Planning Application Reference No.: 3/2026/0168

Address of Development: 19 Browgate, Sawley, Clitheroe

Comments: Re: Objection to Planning Application 3/2026/0168 at 19 Browgate, Sawley BB7 4NB

Proposed - Elevations

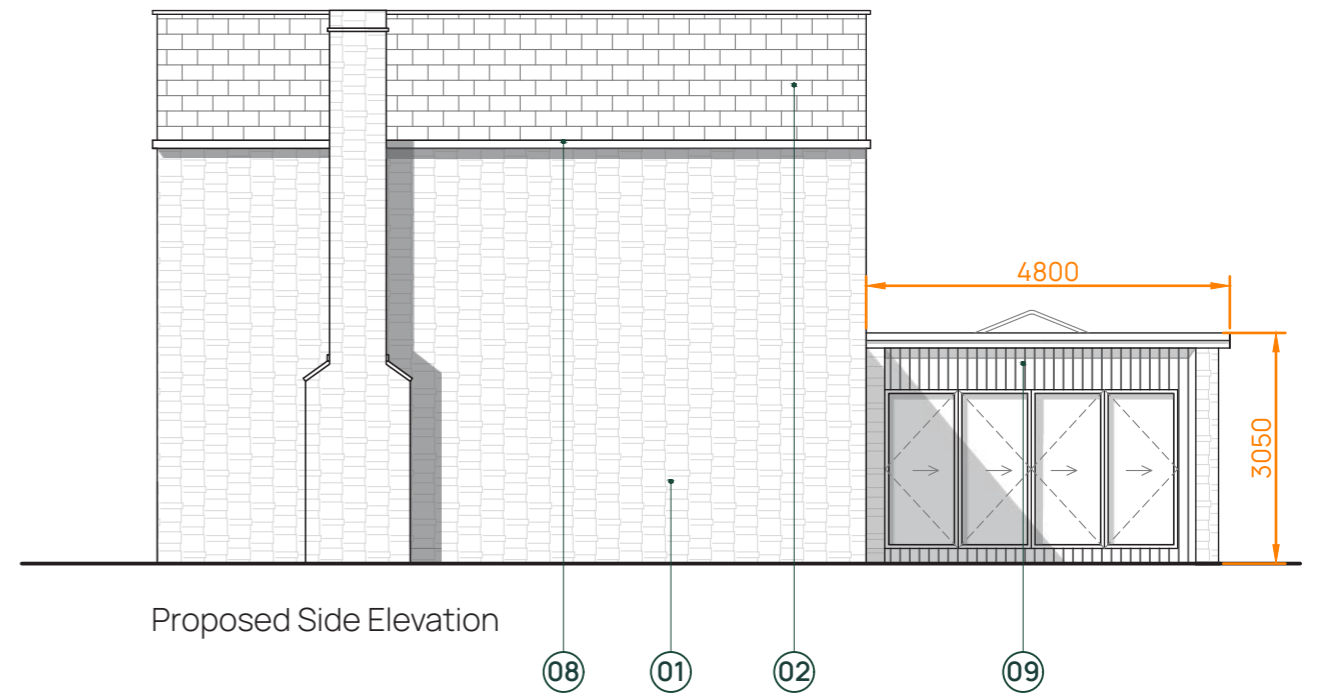
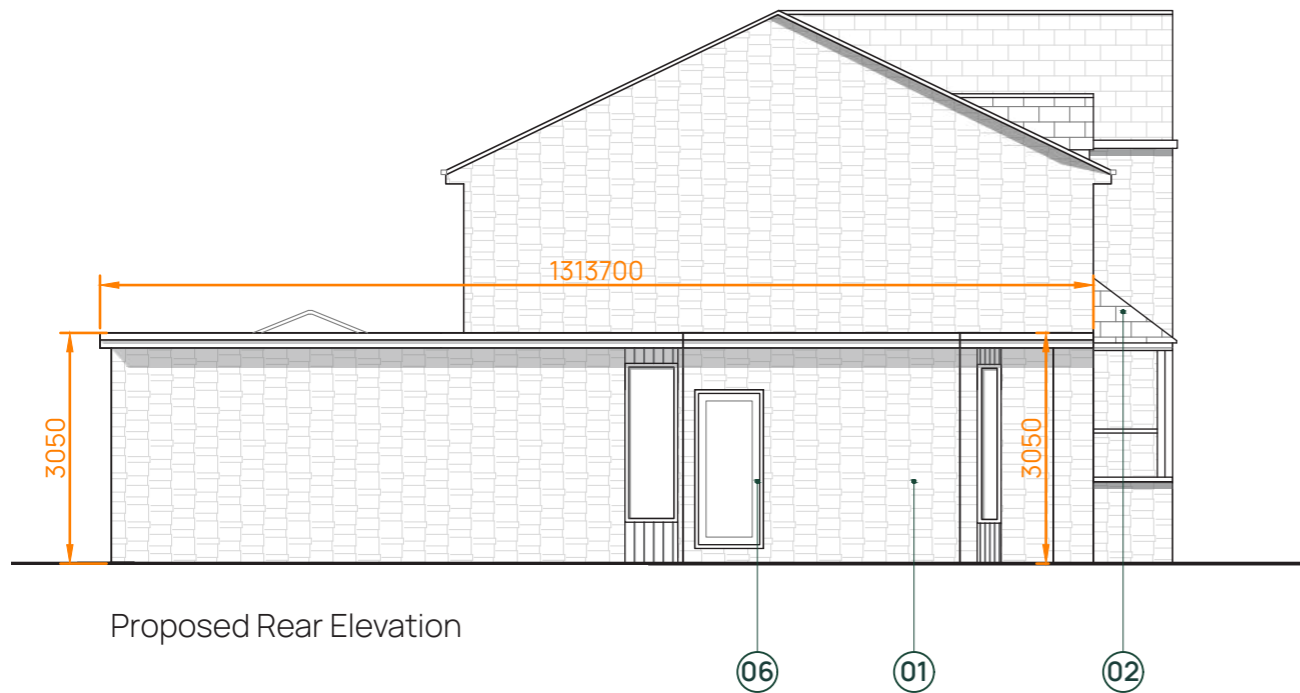
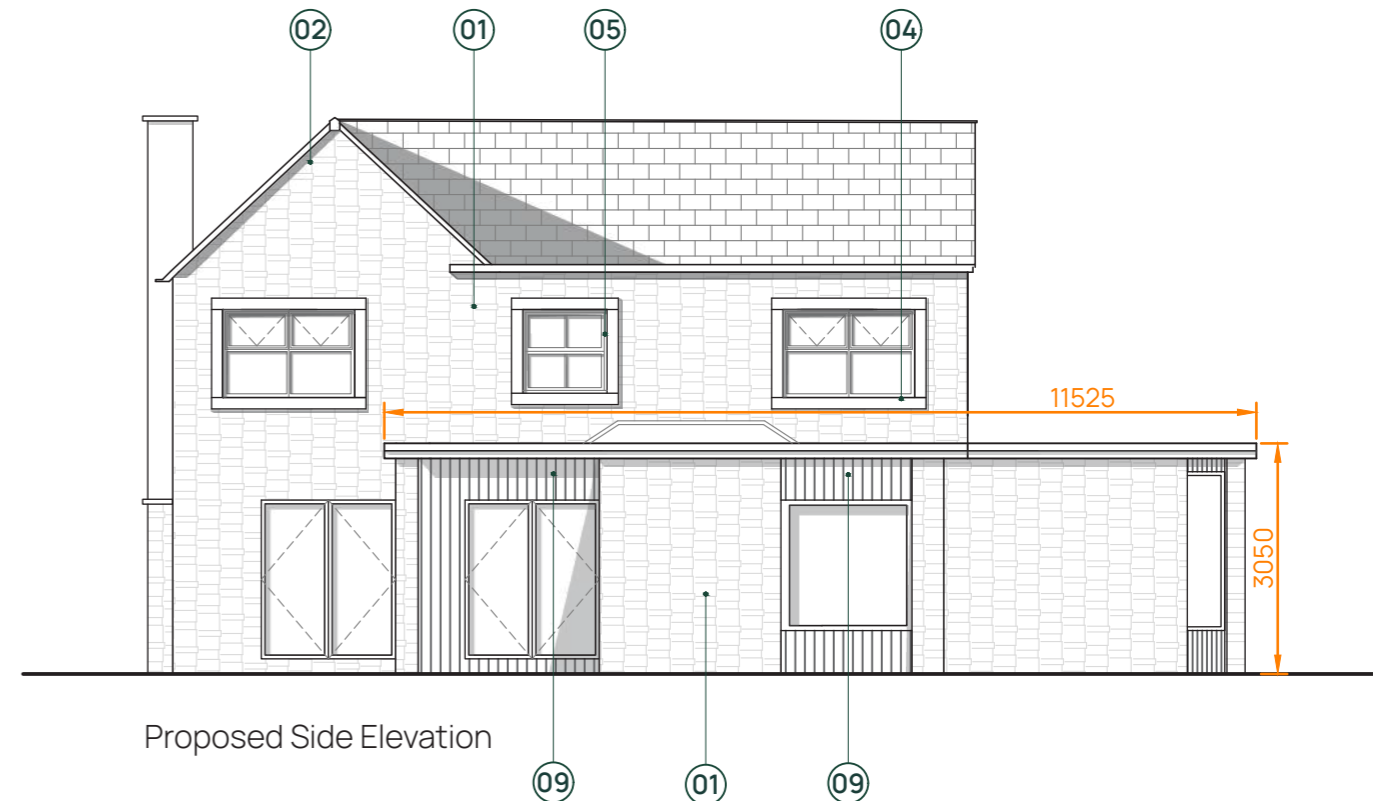
1. Overlooking/Privacy. Based on the plans the extension will be higher than our existing fence line. Therefore the proposed windows, floor to ceiling, on the side of the extension [REDACTED] resulting in a severe loss of privacy.
2. Height of the proposed building against the boundary line, again based on the plans the building will cause shading/loss of light down the [REDACTED].
3. Parking space created at the side of the garage, is a vehicle crossover required as not shown on the plans? Also digging out near [REDACTED], although not a planning issue, [REDACTED].
